MEMORANDUM

DATE: May 20, 2021

SUBJECT: Traffic and Transportation Review
The Ridge at Lorson Ranch Submittal No. 1
FHU Reference No. 117253-06

I have reviewed the materials submitted for the Ridge at Lorson Ranch. The materials include the Traffic Impact Analysis report by LSC Transportation Consultants, Inc. dated April 6, 2021 and the Planned Unit Development and Preliminary Plan by Matrix, dated April 19, 2021. The site is generally located east of existing and ongoing development at Lorson Ranch in El Paso County, Colorado. The Ridge at Lorson Ranch would consist of 994 single family homes, with connection to Marksheffel Road via Fontaine and Lorson Boulevards.

**DT03**

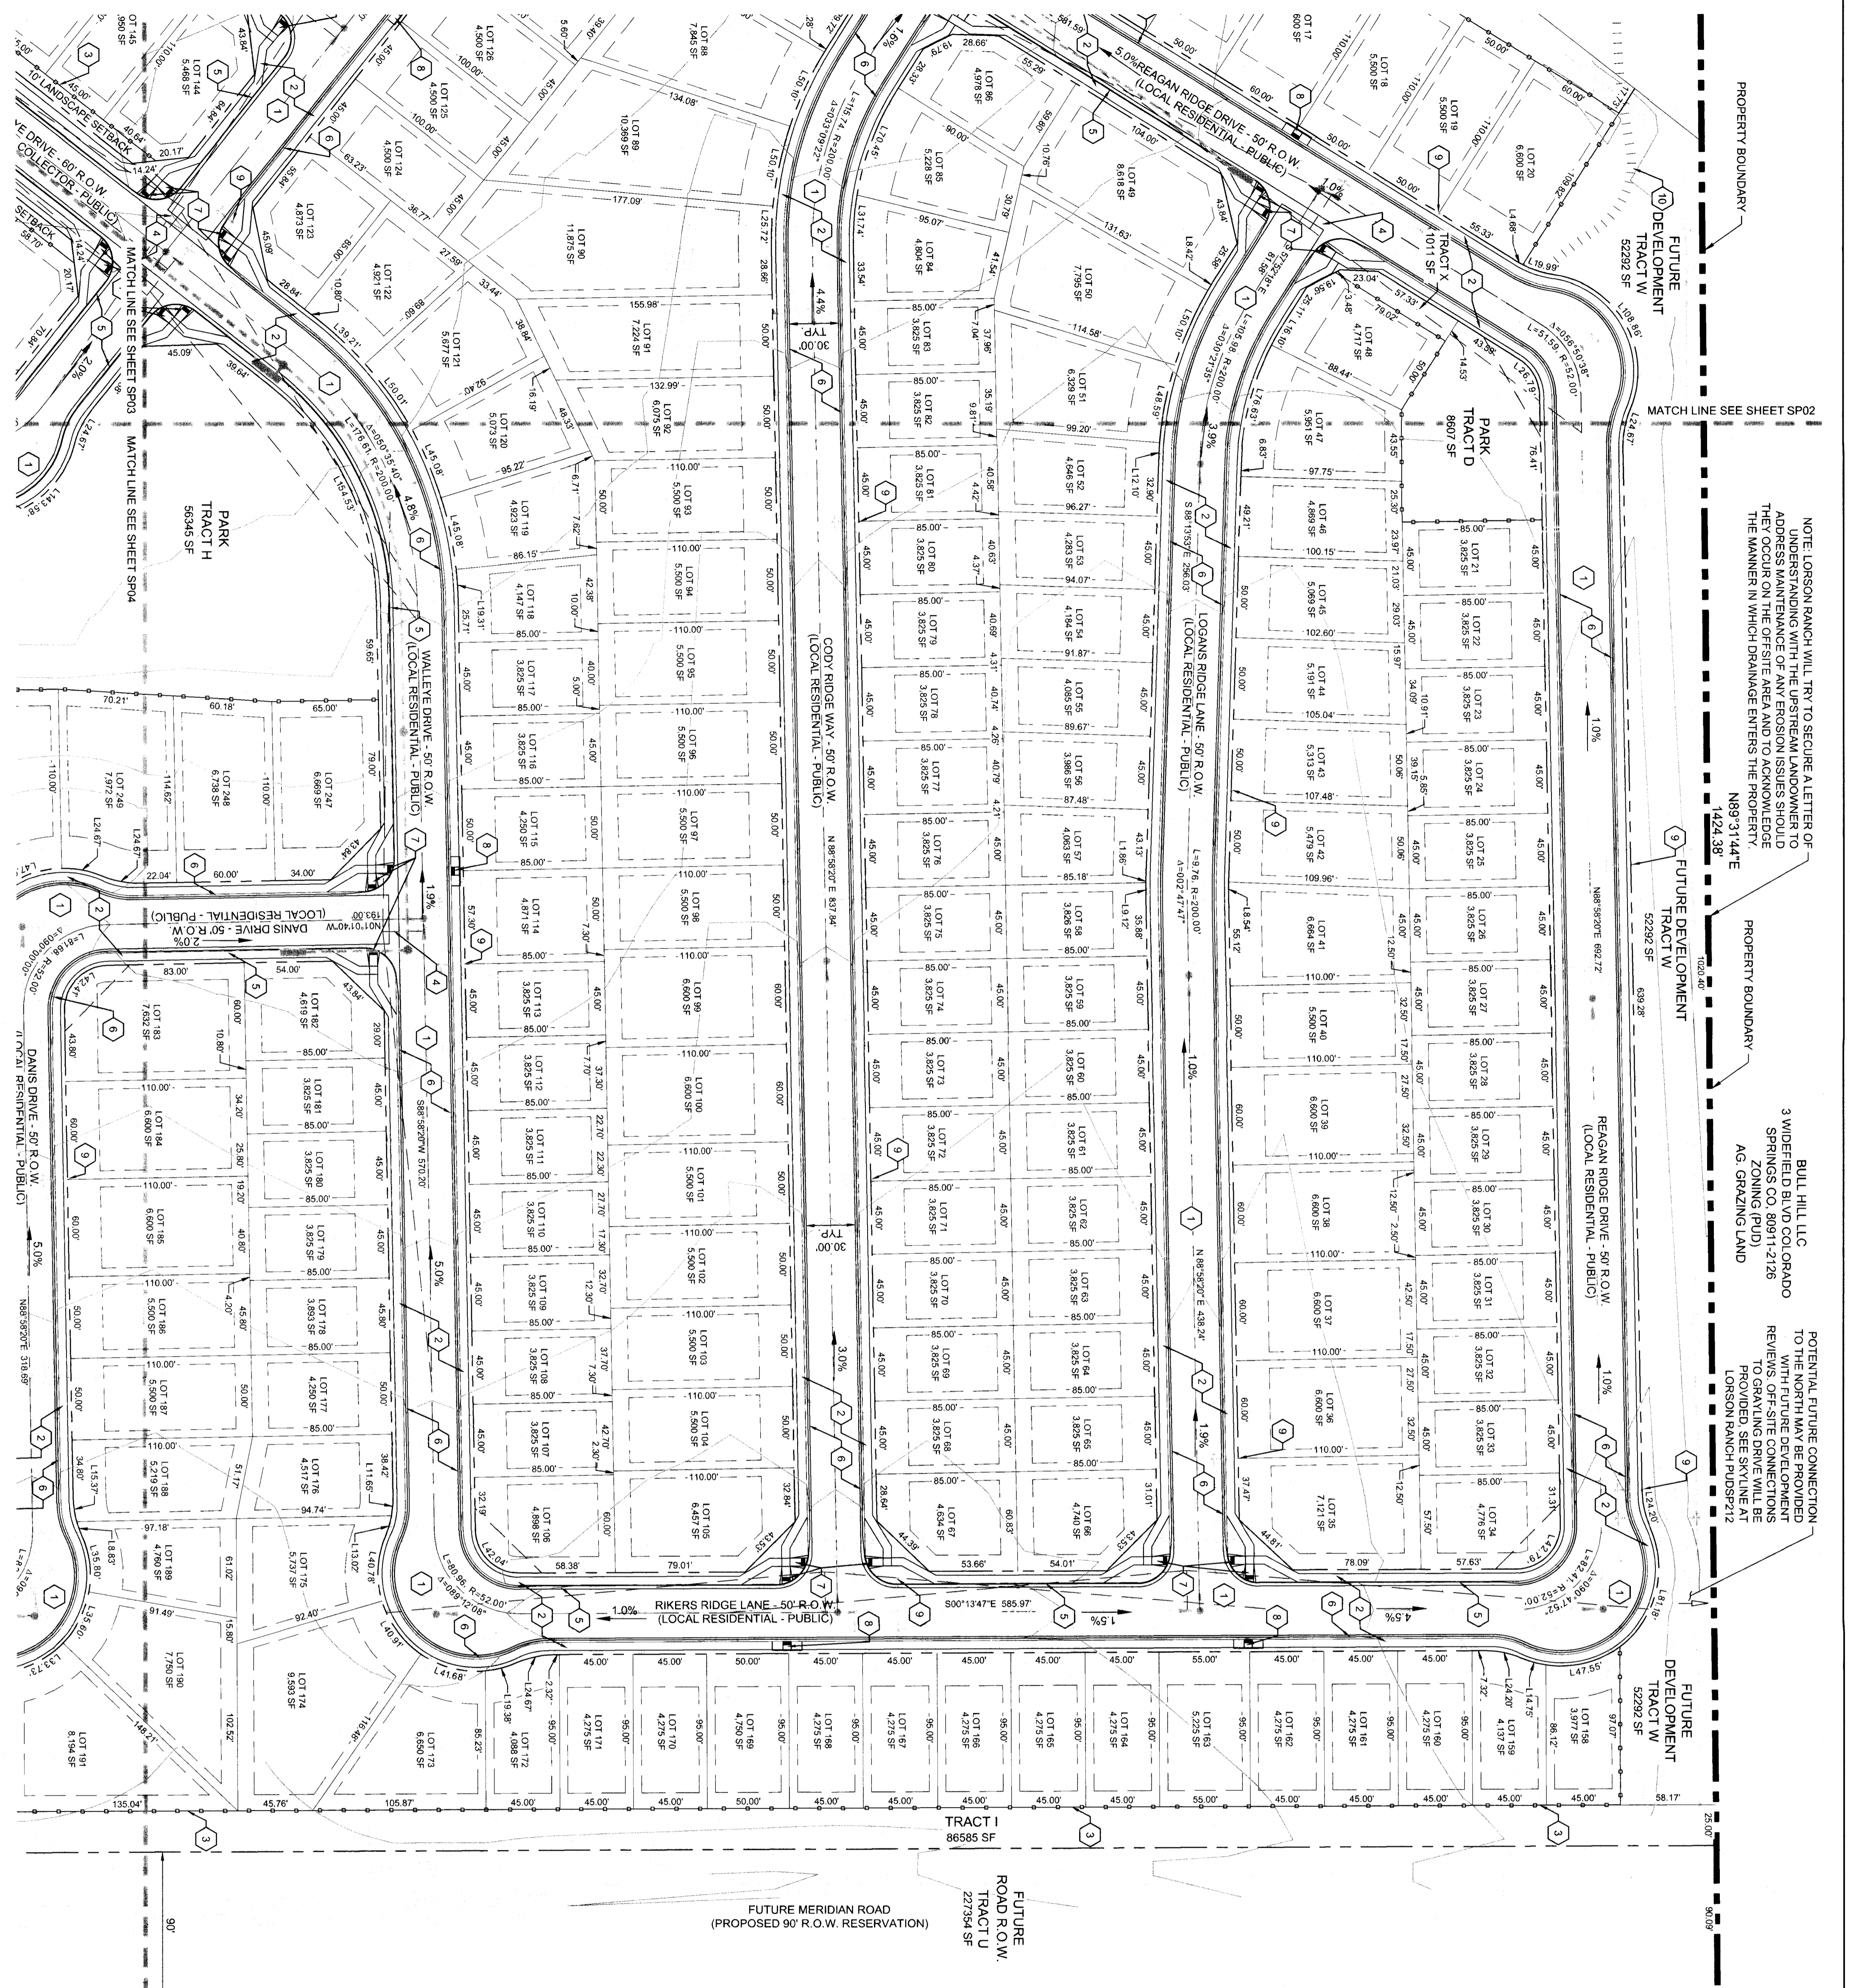
3. Sheet DT03 depicts the proposed typical cross sections. The Residential Urban Local and Residential Urban Collector cross sections match the corresponding typical in the ECM.
4. The cross section for Fontaine Boulevard generally matches the ECM typical cross section for Urban Non-Residential Collectors, except that the right-of-way is shown as 100 feet instead of the standard 80 feet. The proposed section does, however, match the existing cross section at the eastern terminus of Fontaine.
